# A428 Black Cat to Caxton Gibbet improvements

9.88 Schedule of Changes to the Environmental Masterplan

December 2021

Drawing Number: HE551495 - ACM - ELS - GEN_SW_Z_ZZ_DR-LV-0006
 Location: I Type: I Role: I Number: P02

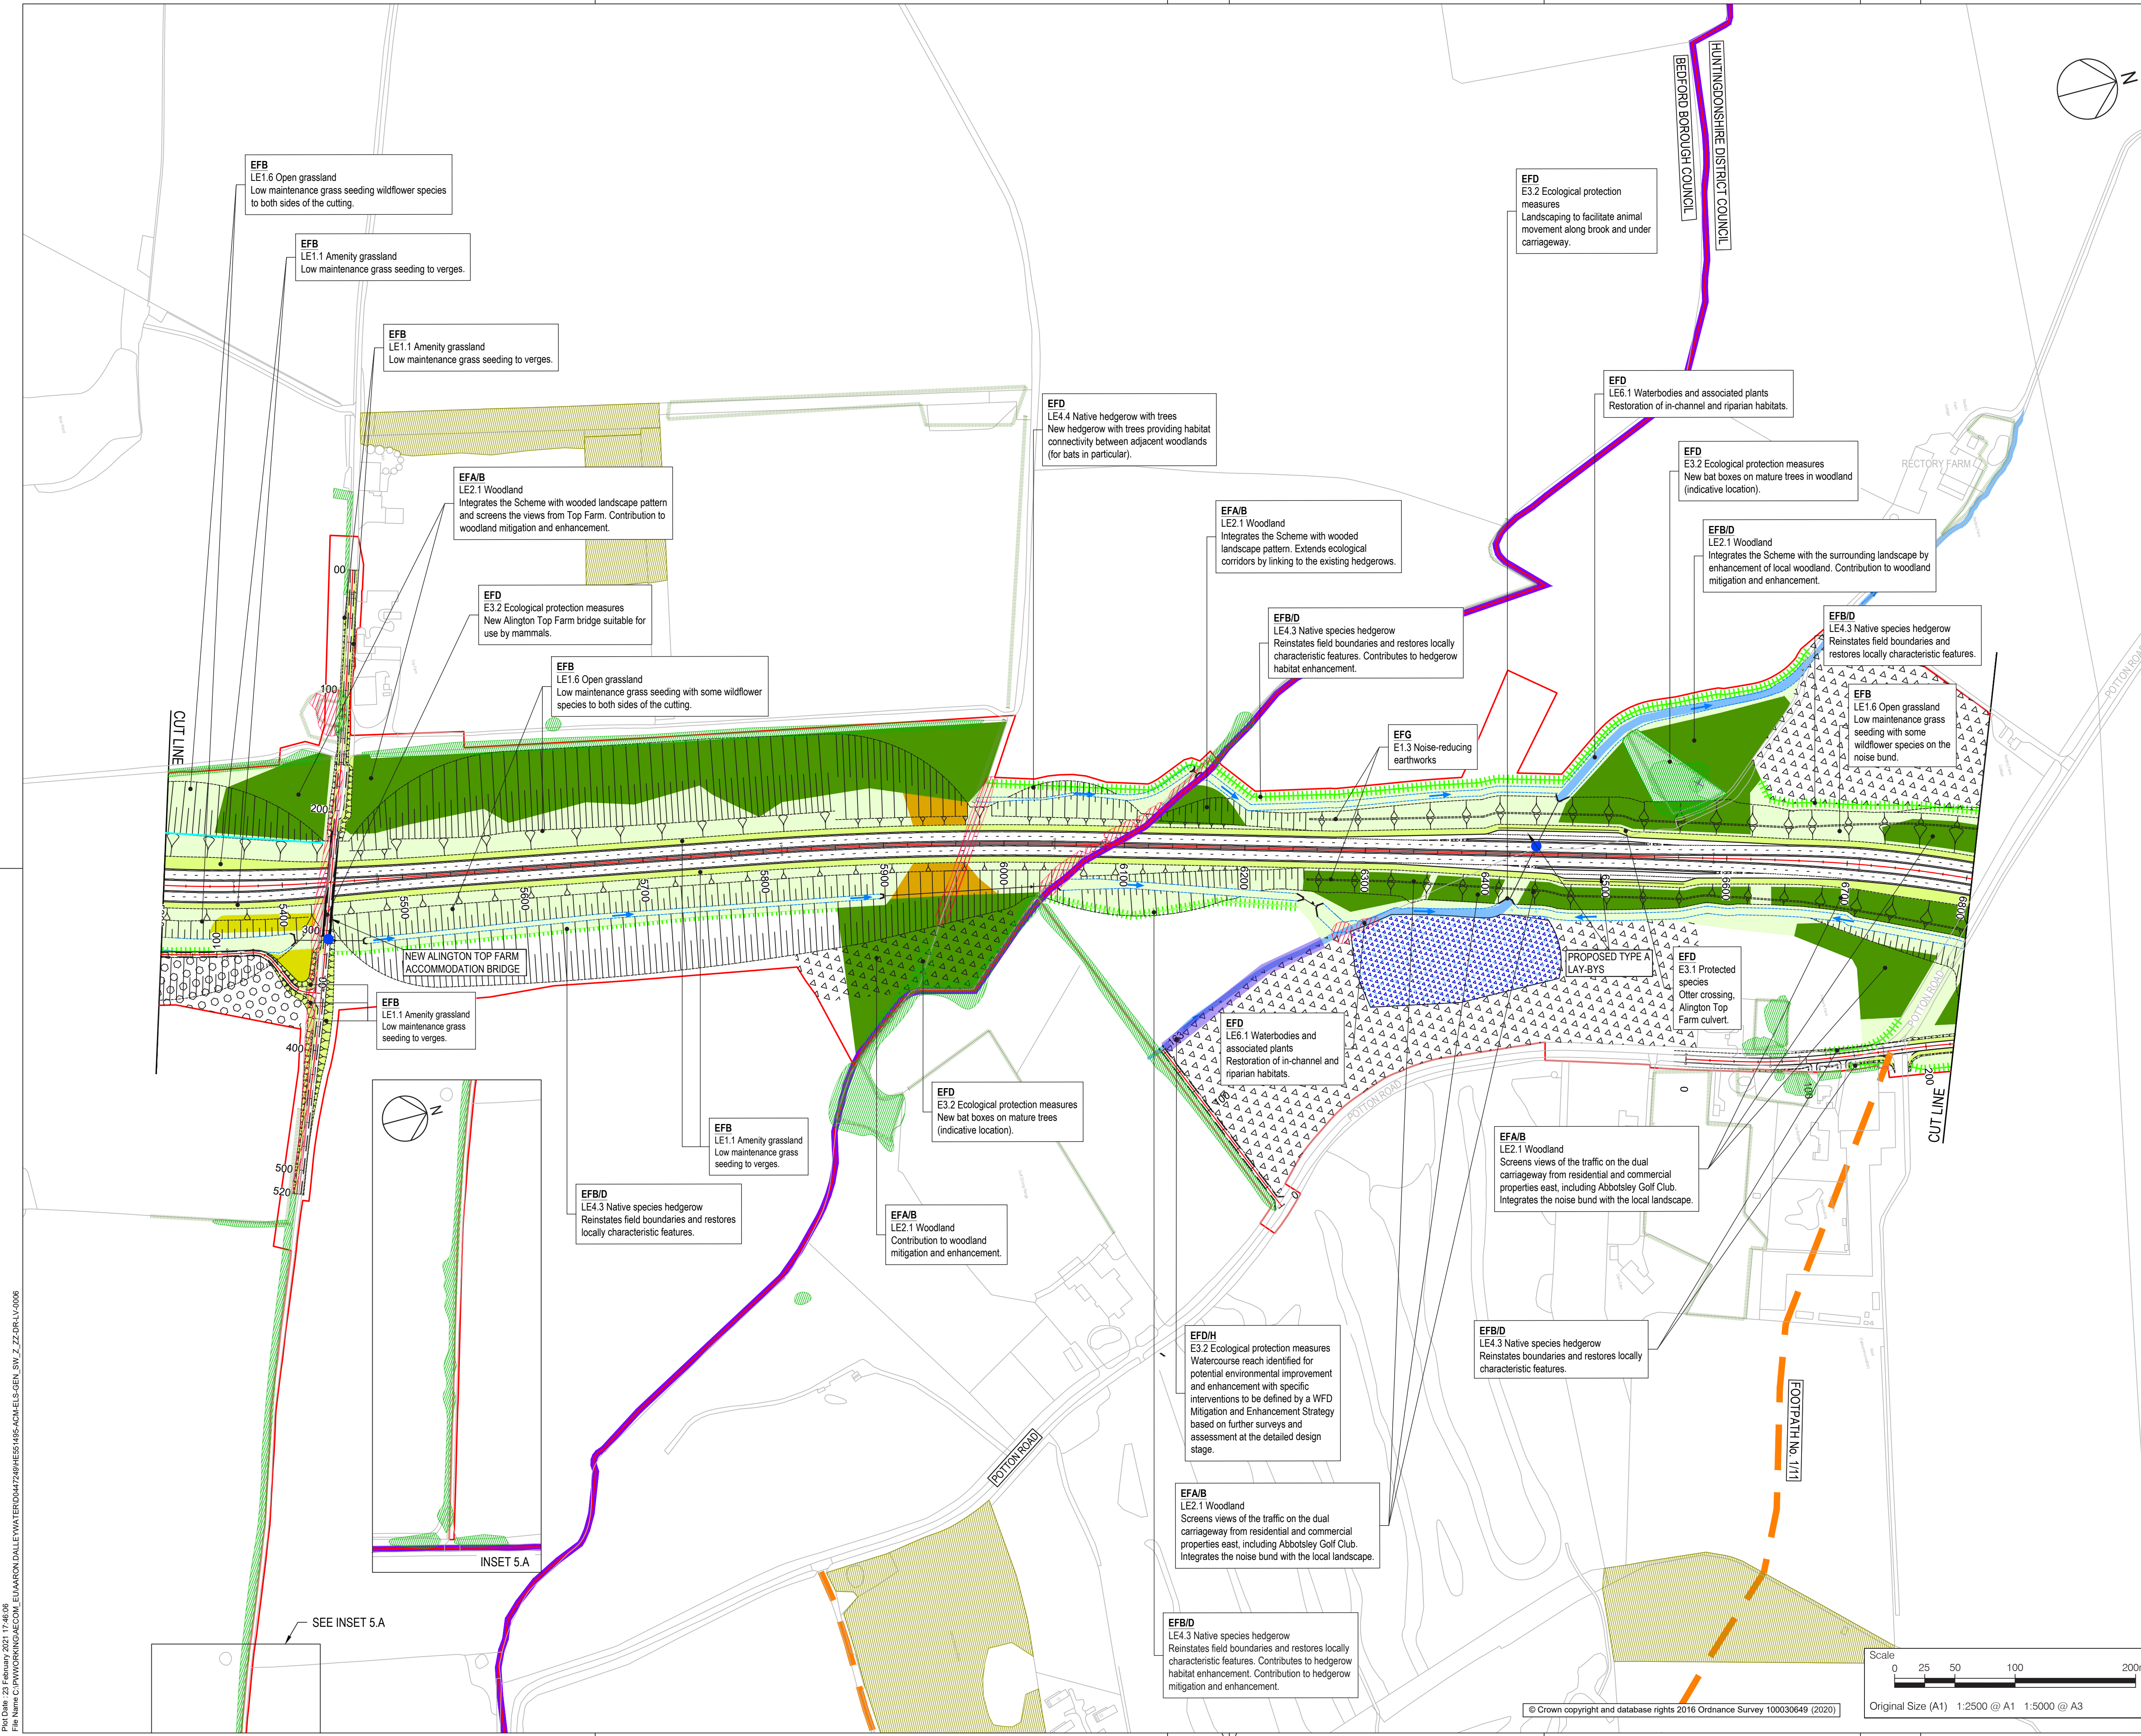
Ref.	Environmental Masterplan page no Ref. with chainage	Consultee	Comments from consultee (Rationale for the change)	Change made	Deadline submitted	Environmental Masterplan Version
		Fragmentation) part a				
7	DR-LV-0006 between chainage 5900 - 6000	Natural England	GCN Mitigation Licence	LE1.3 Species rich grassland Tussocky grass mix as terrestrial habitat for Great Crested Newts.	Deadline 6	Figure 2.4v3
8	DR-LV-0006 between chainage 6600 - 6700	Natural England	GCN Mitigation Licence	LE6.1 Waterbodies and associated plants, pond proposed as receptor site for GCN.	Deadline 6	Figure 2.4v3
9	DR-LV-0010 between chainage 10300 - 10400	Natural England	GCN Mitigation Licence	LE1.3 Species rich grassland Tussocky grass mix as terrestrial habitat for Great Crested Newts.	Deadline 6	Figure 2.4v3
10	DR-LV-0010 between chainage 10200 - 10300	Natural England	GCN Mitigation Licence	LE6.1 Waterbodies and associated plants, pond proposed as receptor site for GCN.	Deadline 6	Figure 2.4v3

Revision Details		By	Date	Suffix
NH logo update, marking Crossing point 2 and 3		EJ	08/12/21	P02

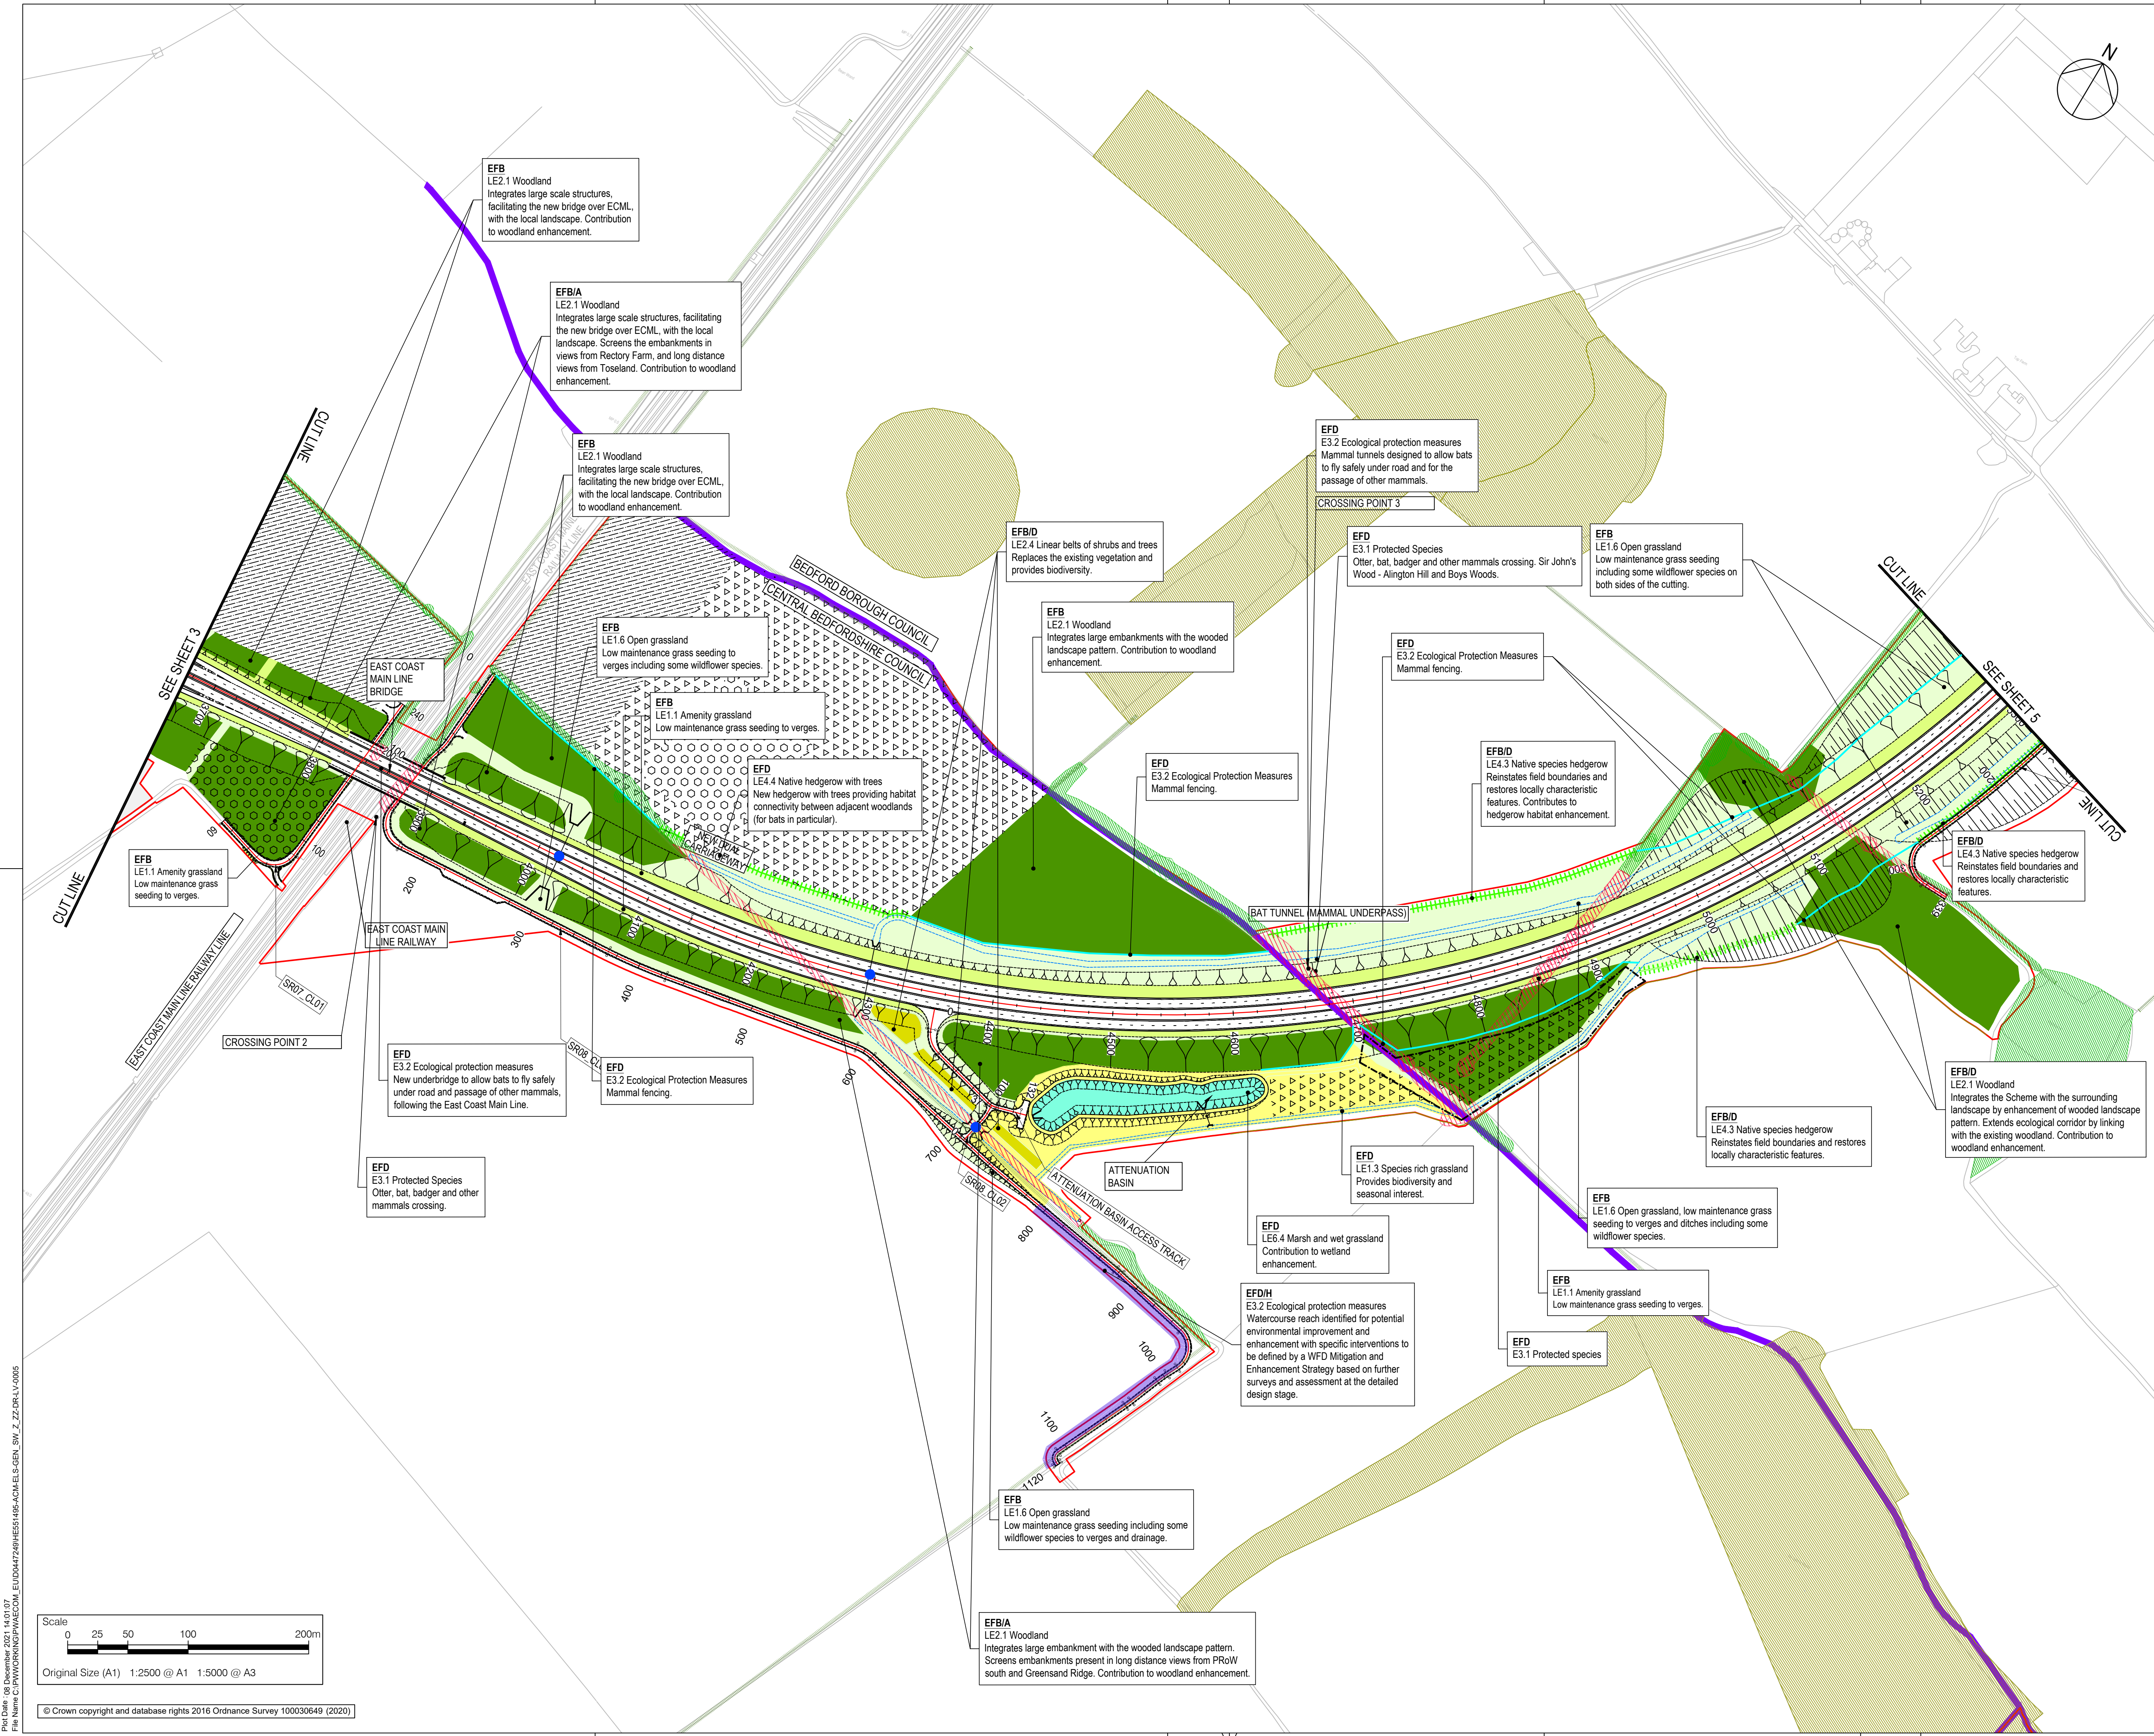
Ref.	Environmental Masterplan page no Ref. with chainage	Consultee	Comments from consultee (Rationale for the change)	Change made	Deadline submitted	Environmental Masterplan Version
1	All Sheets	N/A – Response to National Highways rebrand	Reflecting the name change from Highways England to National Highways and the updated branding of National Highways.	National Highways logo updated.	Deadline 4	Figure 2.4v2
2	DR-LV-0004 between chainage 2400 - 2500	ExA Raised in Written Question 2 [PD-009] Q2.3.5.1 (Habitat Fragmentation) part a	Providing greater clarity for the identification of crossing points on the masterplan.	Label for Crossing Point 1 added for identification, on the eastern bank, adjacent to the River Great Ouse.	Deadline 4	Figure 2.4v2
3	DR-LV-0005 between chainage 3800 – 3900	ExA Raised in Written Question 2 [PD-009] Q2.3.5.1 (Habitat Fragmentation) part a	Providing greater clarity for the identification of crossing points on the masterplan.	Label for Crossing Point 2 added for identification, on the East Coast Main Line Railway Line.	Deadline 4	Figure 2.4v2
